31 October 2017

Our Ref RR-008
Your Ref EN010081

**Application by Eggborough Power Limited for an Order Granting Development Consent for the Eggborough CCGT (Generating Station)
Written Representation on behalf of the Canal & River Trust and Response to the Examining Authority's first round of written questions of the Canal & River Trust**

INDICATIVE COFFERDAM ARRANGEMENT
(COOLING WATER DISCHARGE POINT)

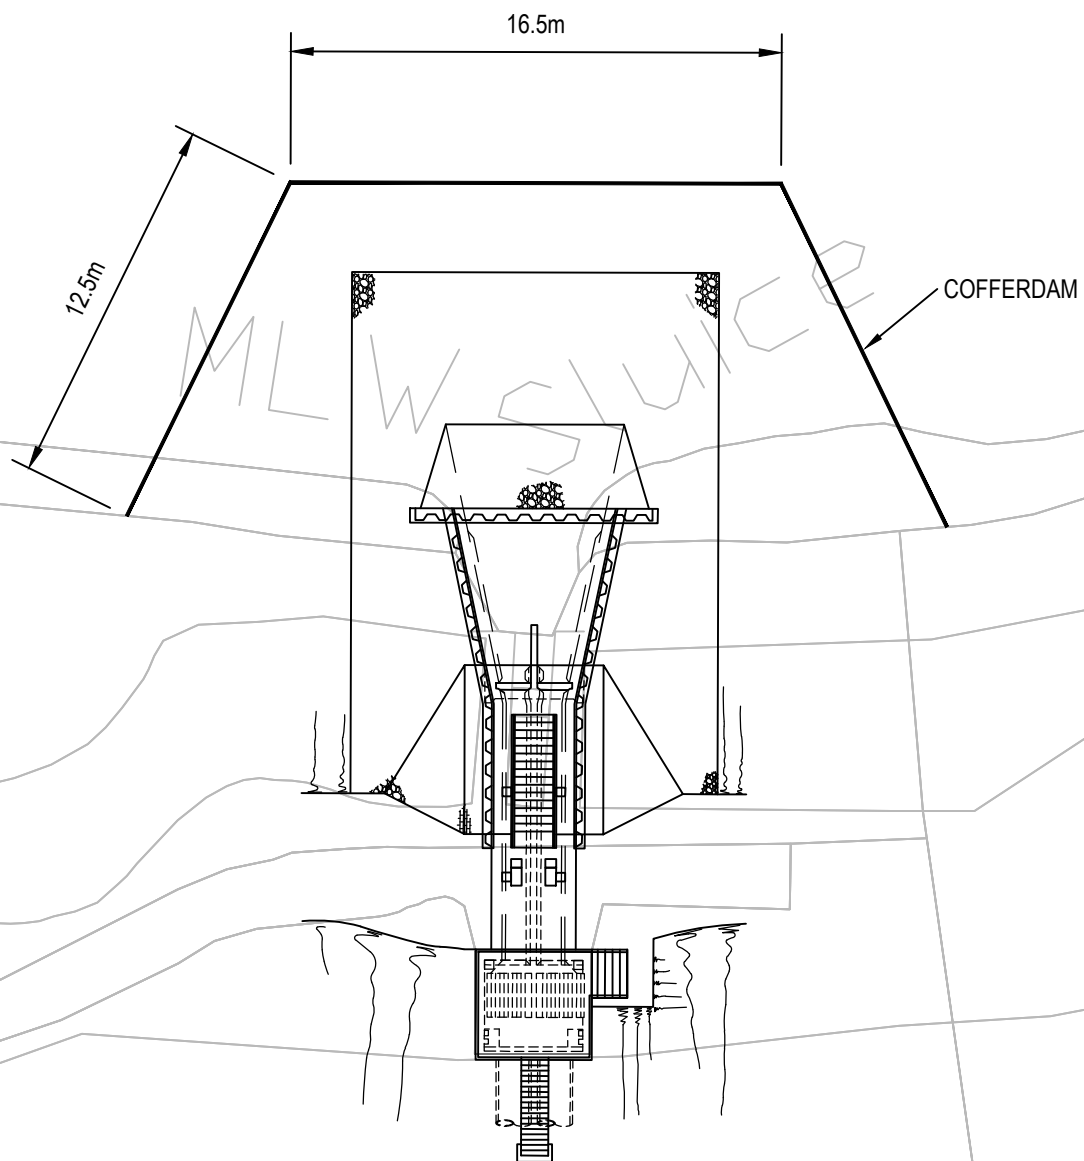
Cofferdams are proposed to be installed temporarily to allow for construction of the new abstraction point (paragraph 5.2.24). Paragraph 5.2.27 of the Environmental Statement does identify the potential environmental impacts of the cofferdam and measures to limit the impact, which is welcomed.

The extent and location of cofferdams will have a direct impact upon navigational activities on the River, and there is a need to ensure that the cofferdams offer suitable protection for boaters, and that the impact of these on river flows can be managed. The Trust's input is crucial to ensure that the impact on river navigation can be fully assessed. The Trust wish for such measures to be fully detailed and provided via condition within the DCO prior to the commencement of works upon the cofferdams.

The Trust identify that the draft DCO includes a requirement in schedule 2, paragraph 5(6)(c) for details of the cofferdams (in terms of timing, phasing, and the extent to which they extend into the River Aire) to be provided prior to the commencement of development comprised in Work No. 4. It refers to the need for consultation with the Environment Agency and Marine Management Organisation. However, as navigation authority for the River Aire at the point of abstraction, we request that the Trust are also consulted as part of the requirements, as this is necessary to ensure that the impact of the cofferdams on navigation can be fully considered.
